## Appeal Decision

**Appeal Ref: APP/R5510/D/24/3347531**

**28 Dawley Avenue, Hillingdon, Uxbridge UB8 3BU**

- The appeal is made under section 78 of the Town and Country Planning Act 1990 (as amended) against a refusal to grant planning permission.
- The appeal is made by Mr Surpal Singh against the decision of the Council of the London Borough of Hillingdon.
- The application Ref is 14440/APP/2024/428.
- The development proposed is rear extension with double storey side and part first storey extension and front porch.

PROPOSED GROUND FLOOR PLAN

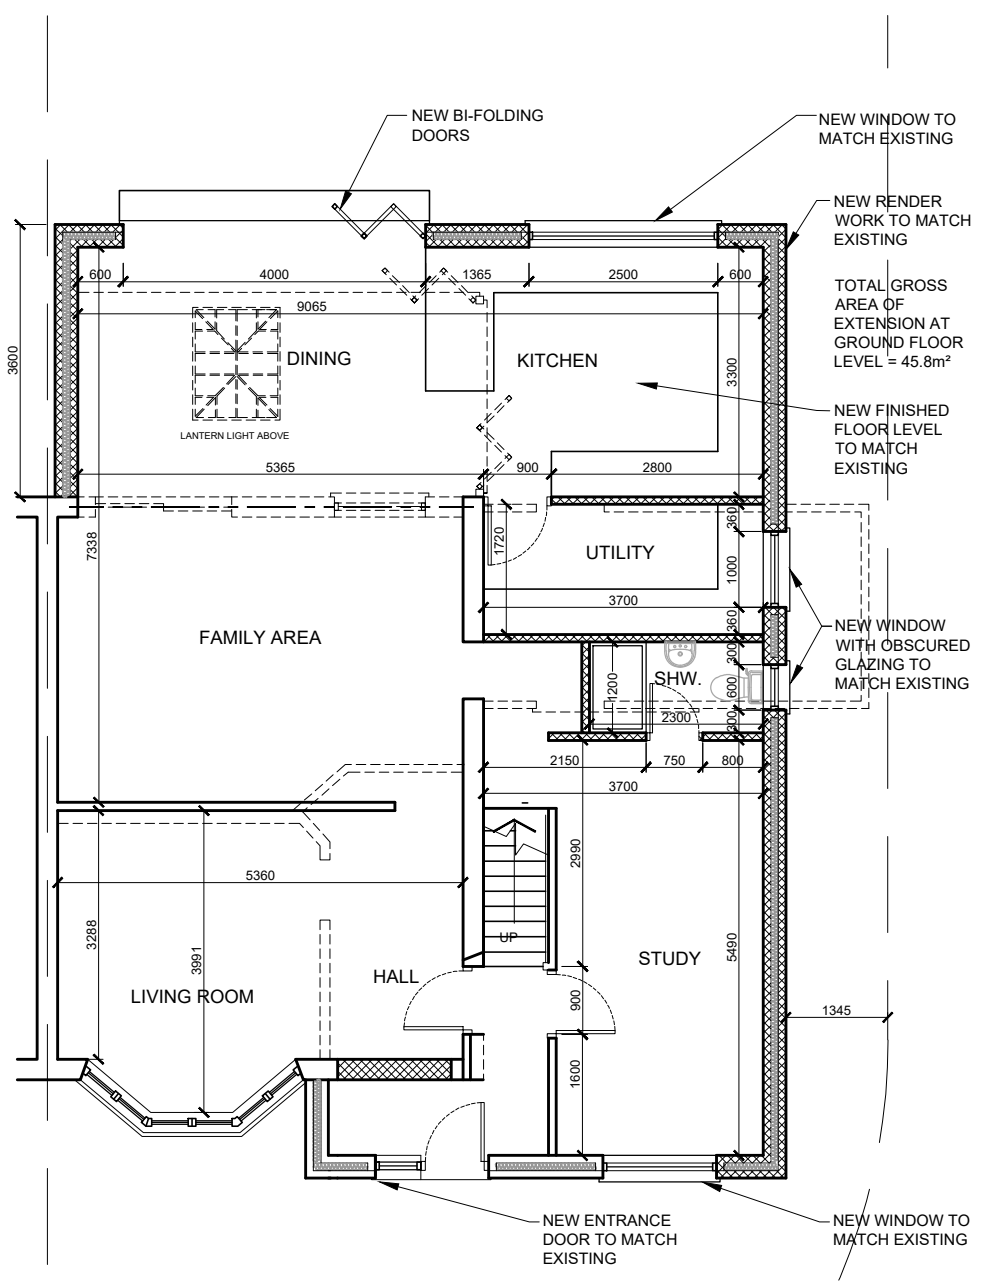
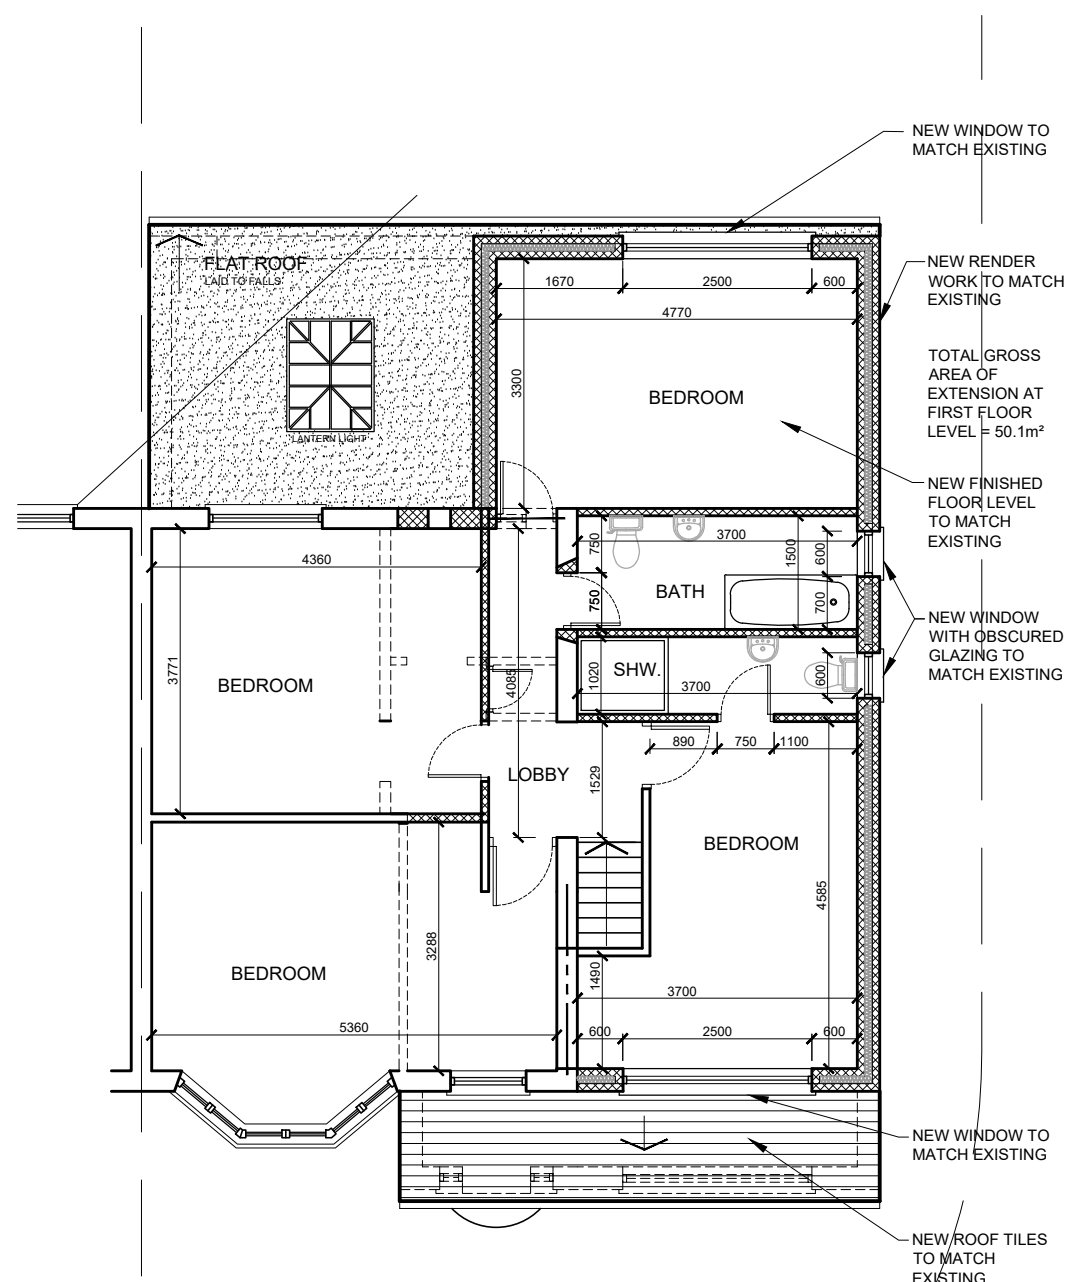
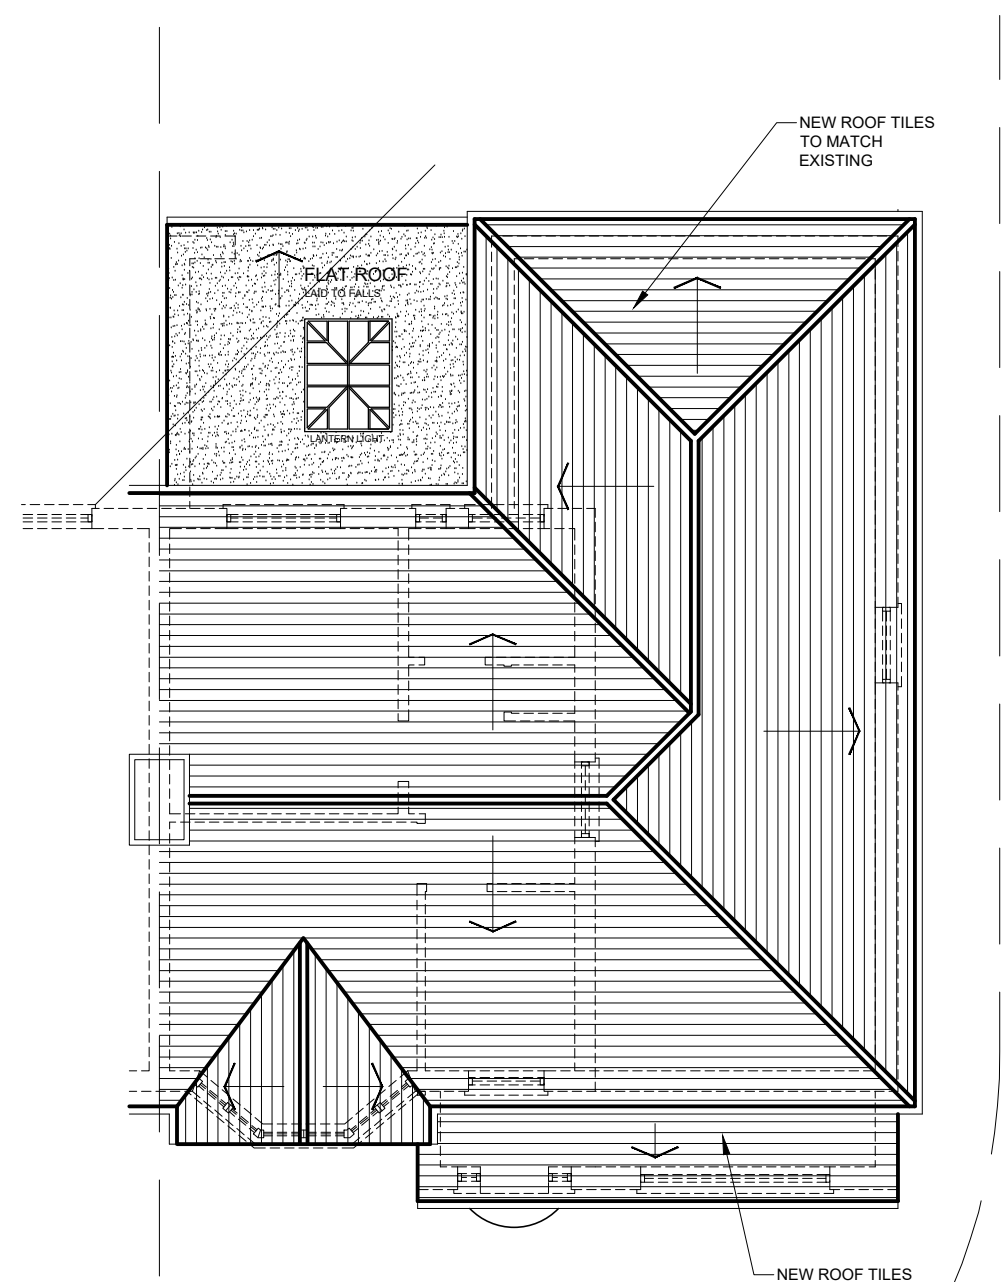
4. The proposal seeks to erect a double storey side extension, single storey rear extension, and single storey front extension at the appeal property. It would be constructed from matching materials and would continue the existing roof form. However, it would significantly change the appearance of the dwelling, adding a large volume of bulk that would alter the current character and proportions of the property. Although an element of offset from the side boundary would remain, the proposal would nevertheless bring the two storey built form much closer to Chester Close, further beyond the return building line of dwellings on this street, thus reducing openness. Overall, the proposal would be a prominent addition to the streetscene, particularly notable due to its corner plot position.

stipulations regarding side extensions. In particular, by exceeding half the width of the original dwelling and not being set back one metre behind the front elevation, the proposed side extension would fail to comply with the requirements of Policy DMHD1, further highlighting it as a visually harmful addition to the site.

PROPOSED BLOCK PLAN SCALE 1:200

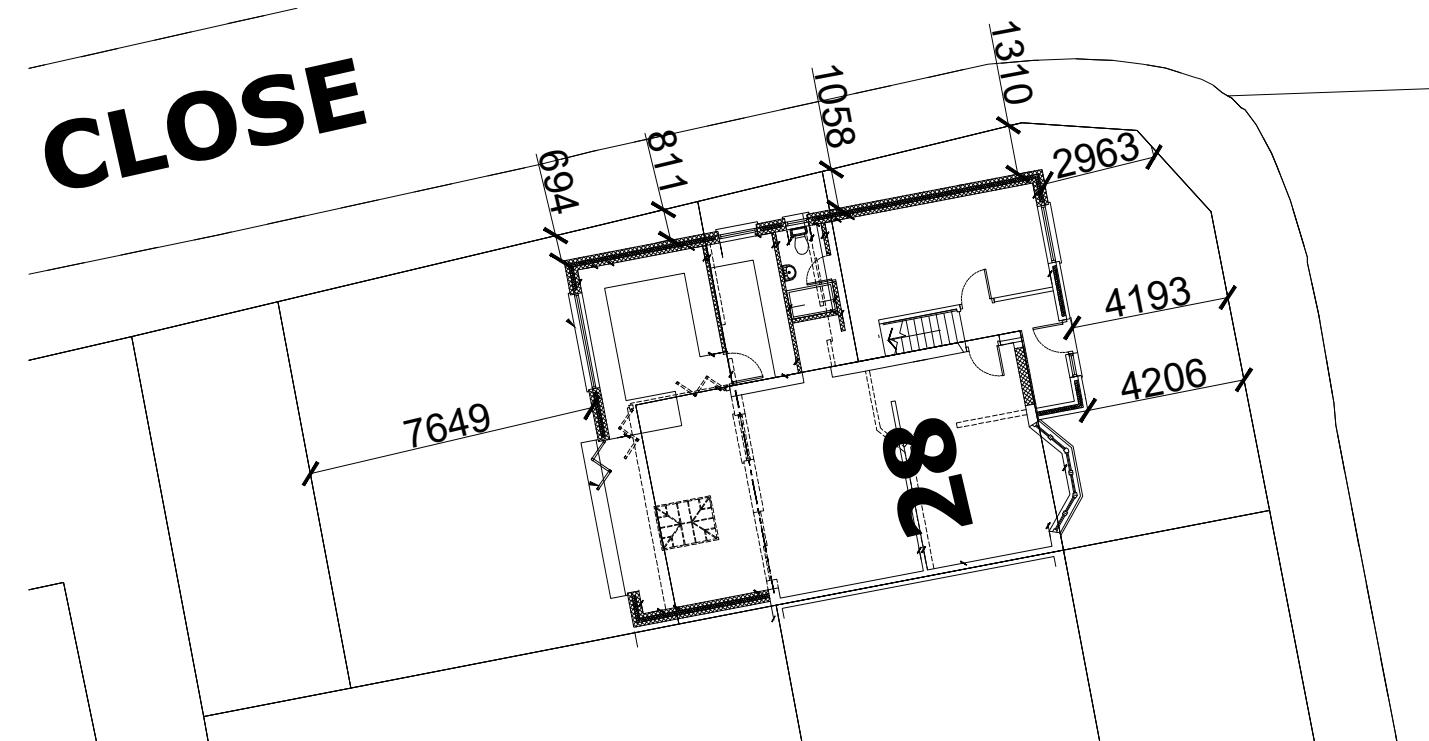
3. The appeal site comprises a two storey dwelling on Dawley Avenue, at the junction with Chester Close. The surrounds are residential and, although dwellings are of mixed appearance, the appeal property sits in a group where the original, shared design remains apparent, despite alterations. Due to the street layouts, corner properties are common, and the main built form of such dwellings is largely set back from the side boundaries, providing a sense of openness. While the appeal property has a side projection towards Chester Close, its single storey nature retains an element of openness at this location.

7. In any event, I observed Nos. 27 and 27A to read as visually jarring in the immediate vicinity due to the volume and proportions of built form. As such, their presence would not justify the proposal. While it may result in an element of balance to the streetscene, it would nevertheless result in this section of Dawley Avenue appearing overdeveloped and at odds with the character of the surrounds.
